Please ask for: Mrs D Johnson
Email: daun.johnson@arun.gov.uk
Telephone: 01903 737762
Our Ref: LU/240/20/PL
Your Ref:
Date: 11th September 2020

Application for Planning Permission

Development: Demolish existing out buildings & replace with rear extension. This application is in CIL Zone (Zero Rated) as 'other development'.
Location: Felix Dancewear 39 Beach Road Littlehampton BN17 5JA

Drawing Title
Existing Floor Plans and Elevation

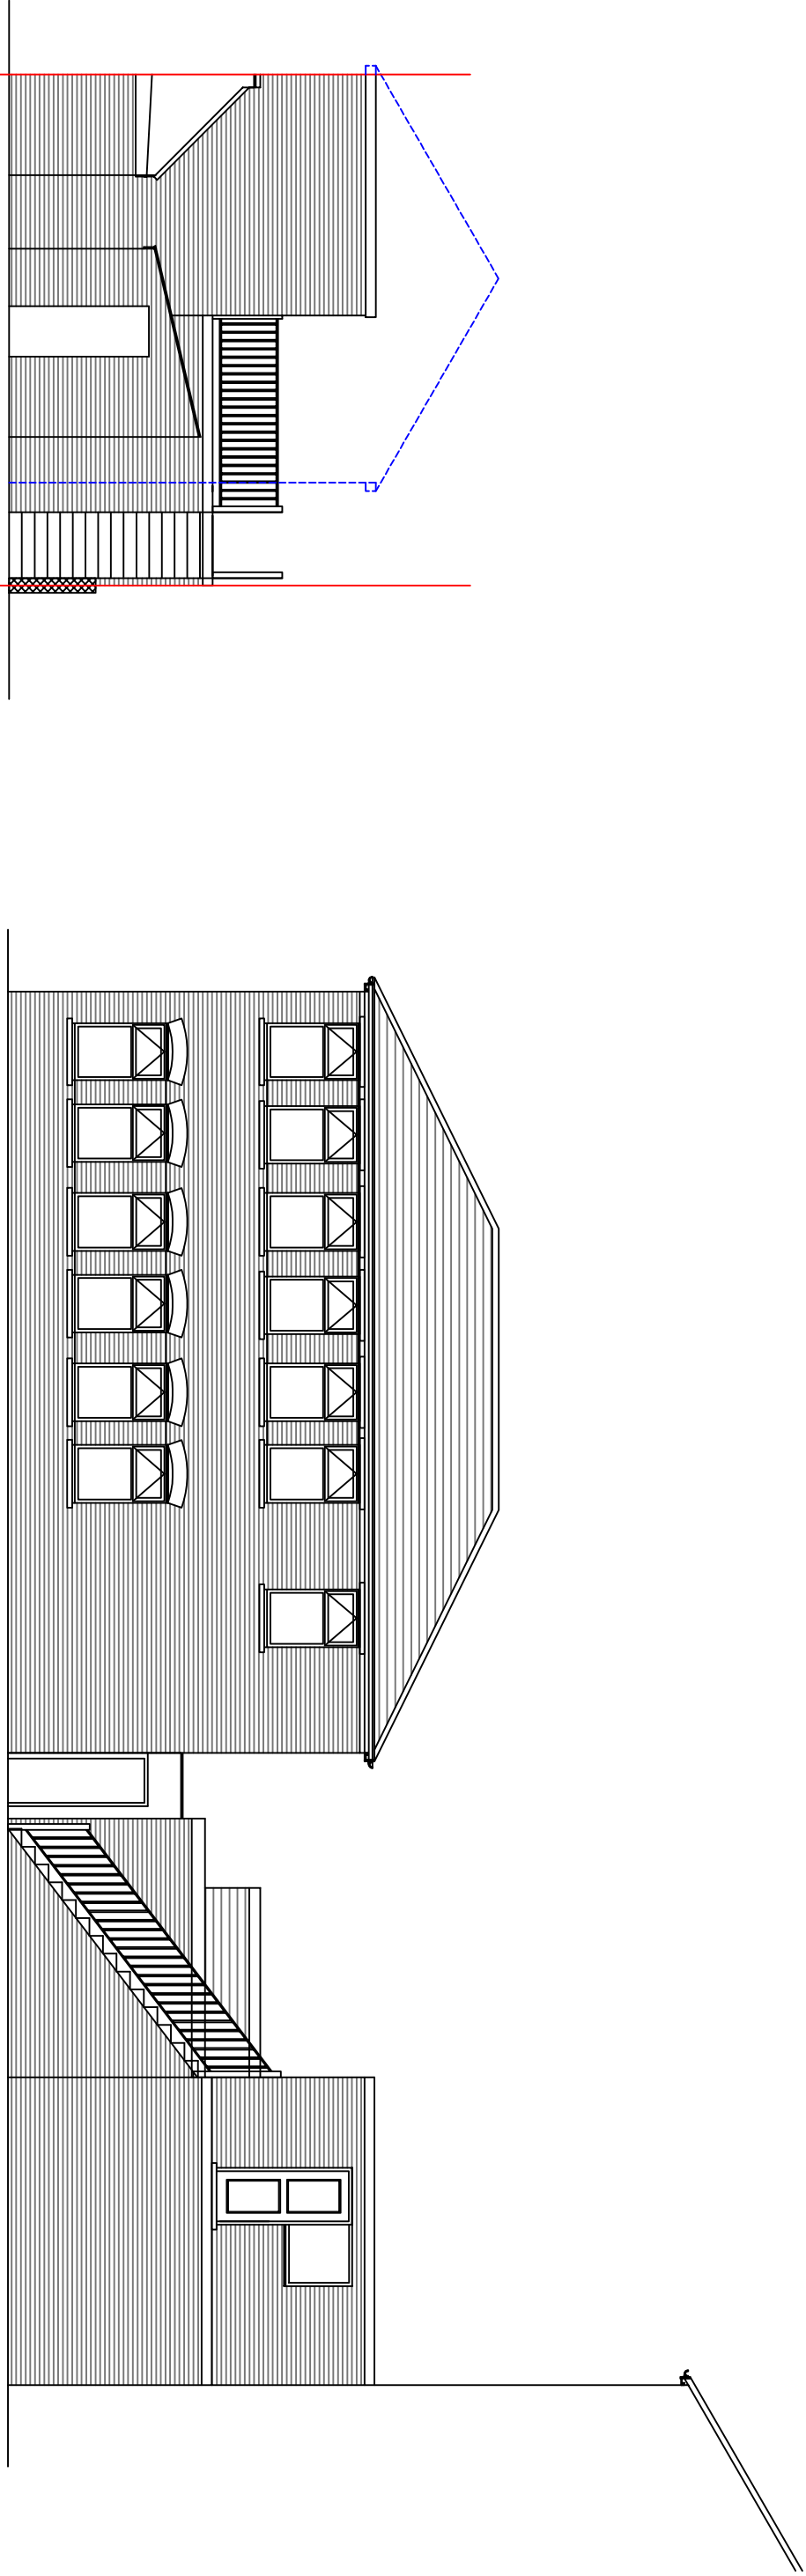
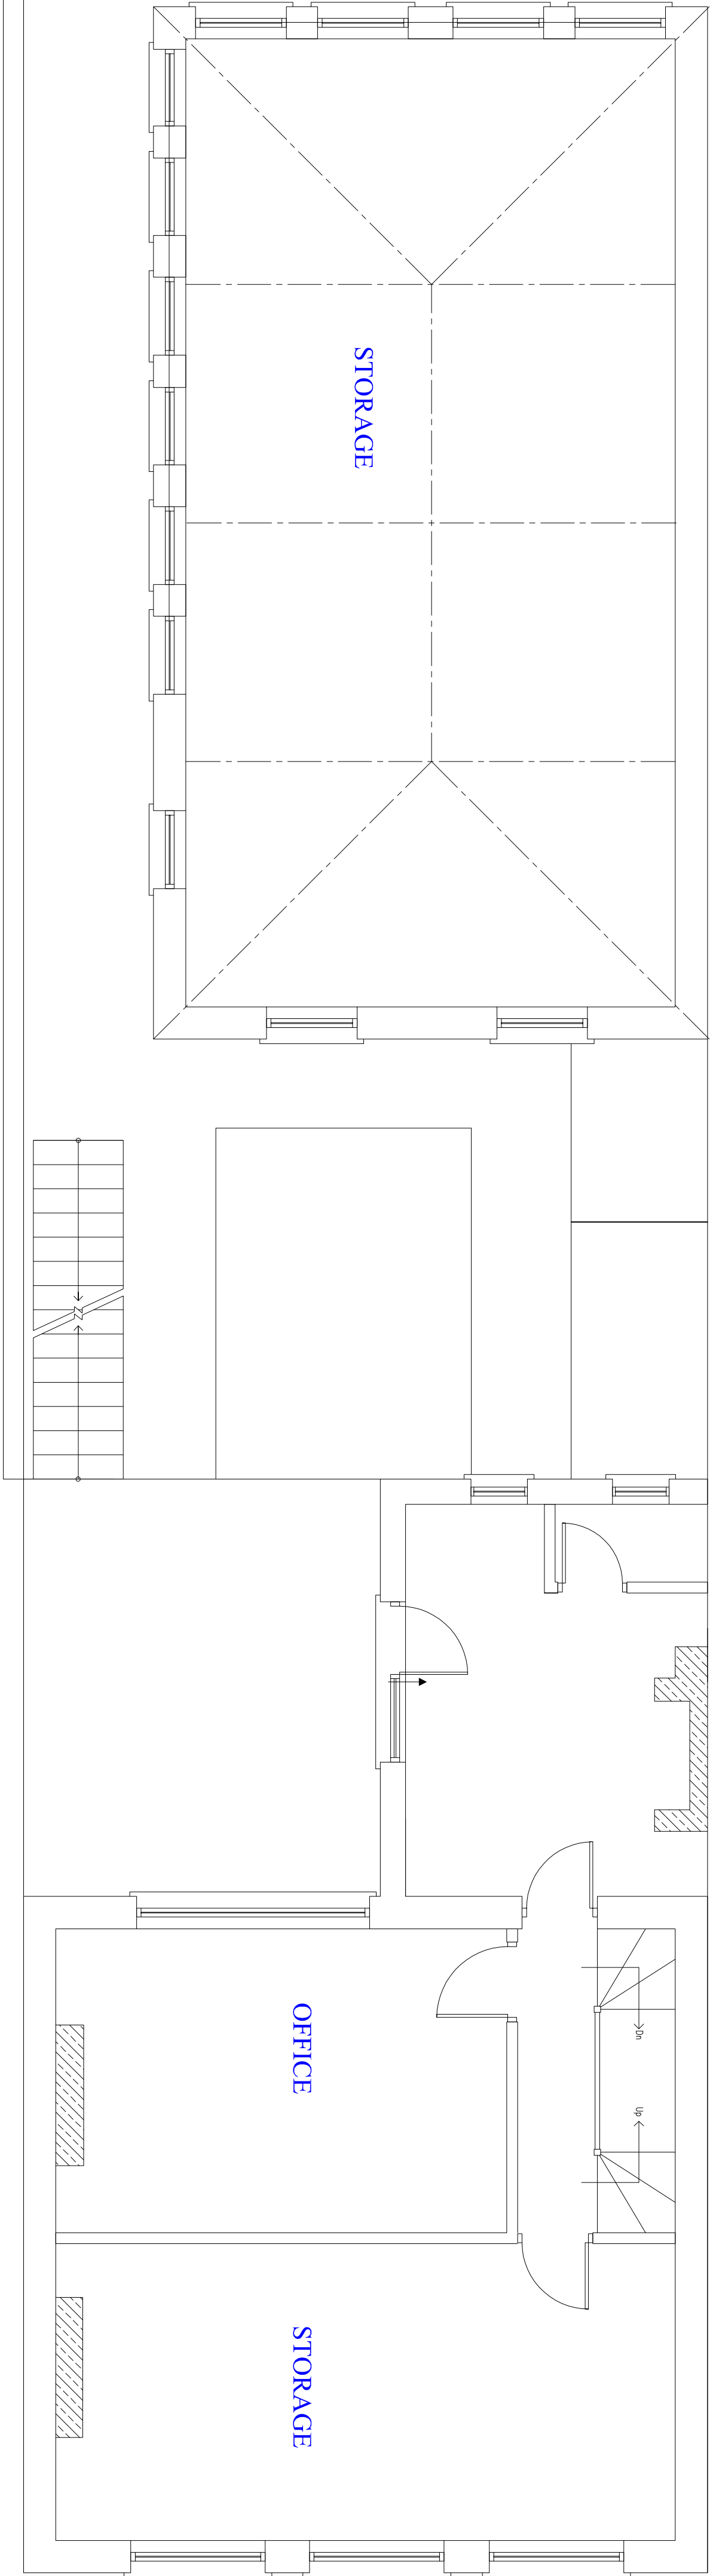
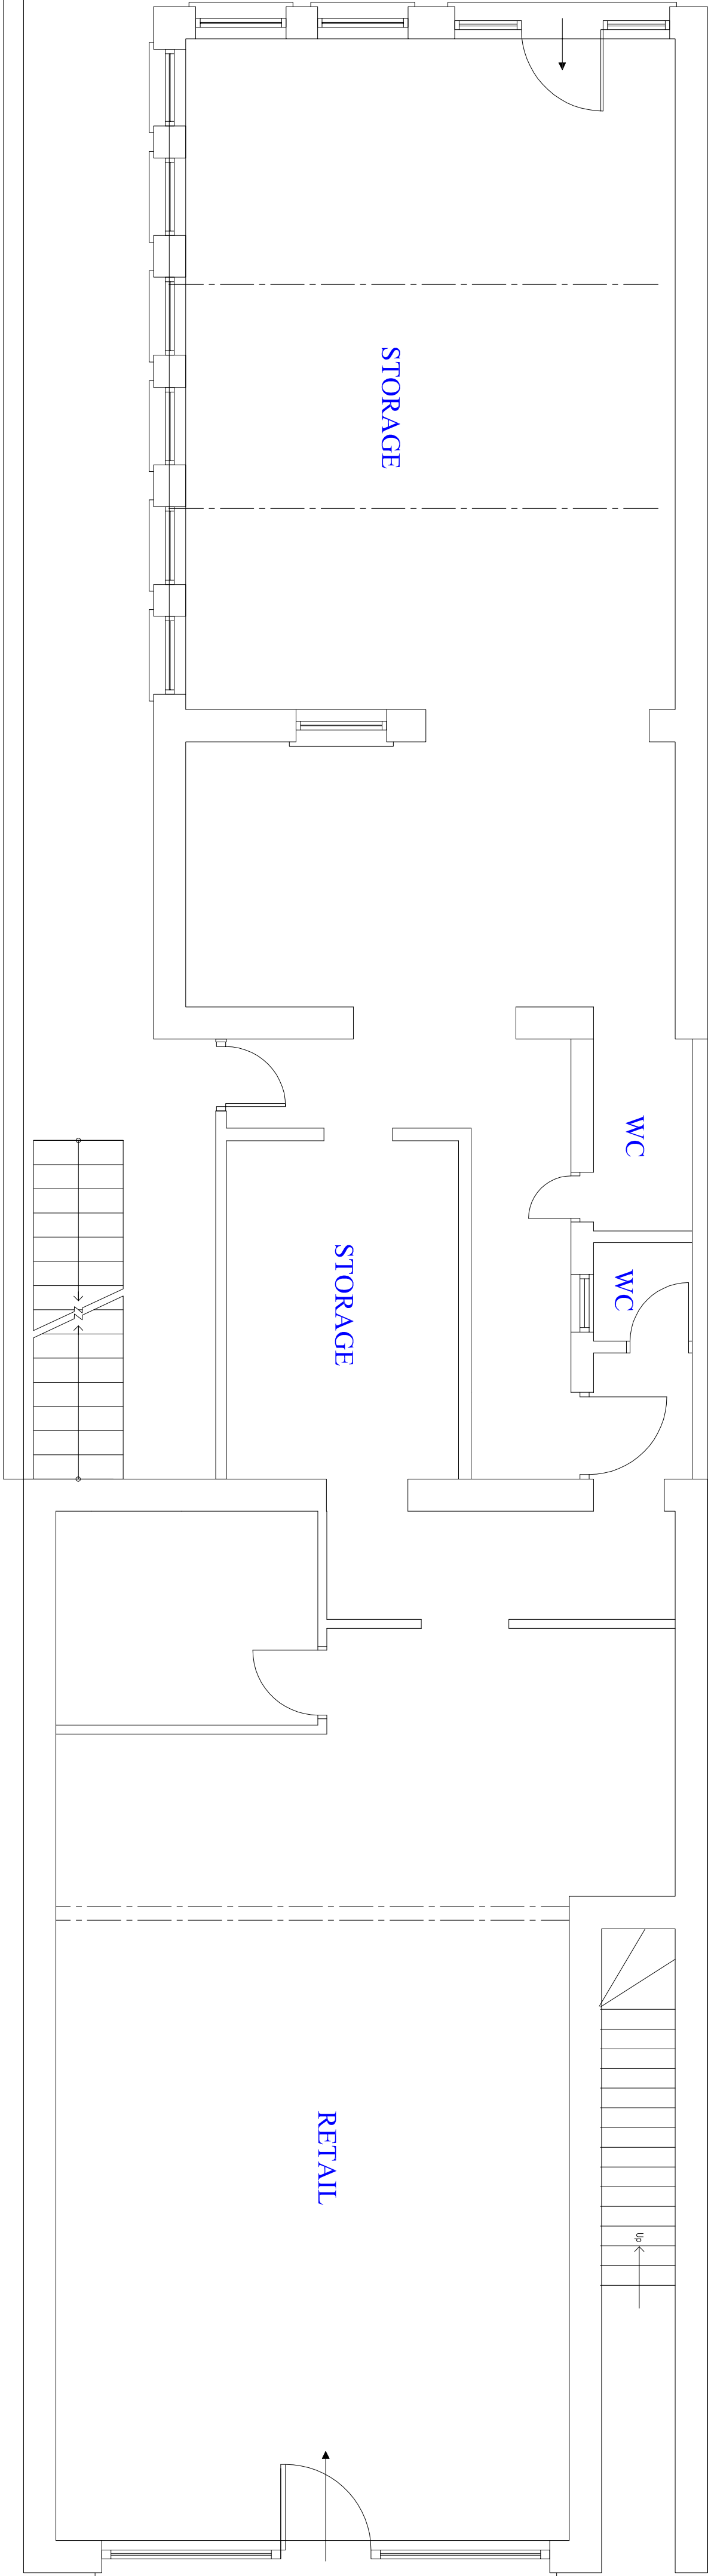
The existing and proposed side elevations and floor plans do not accord. Please amend accordingly.
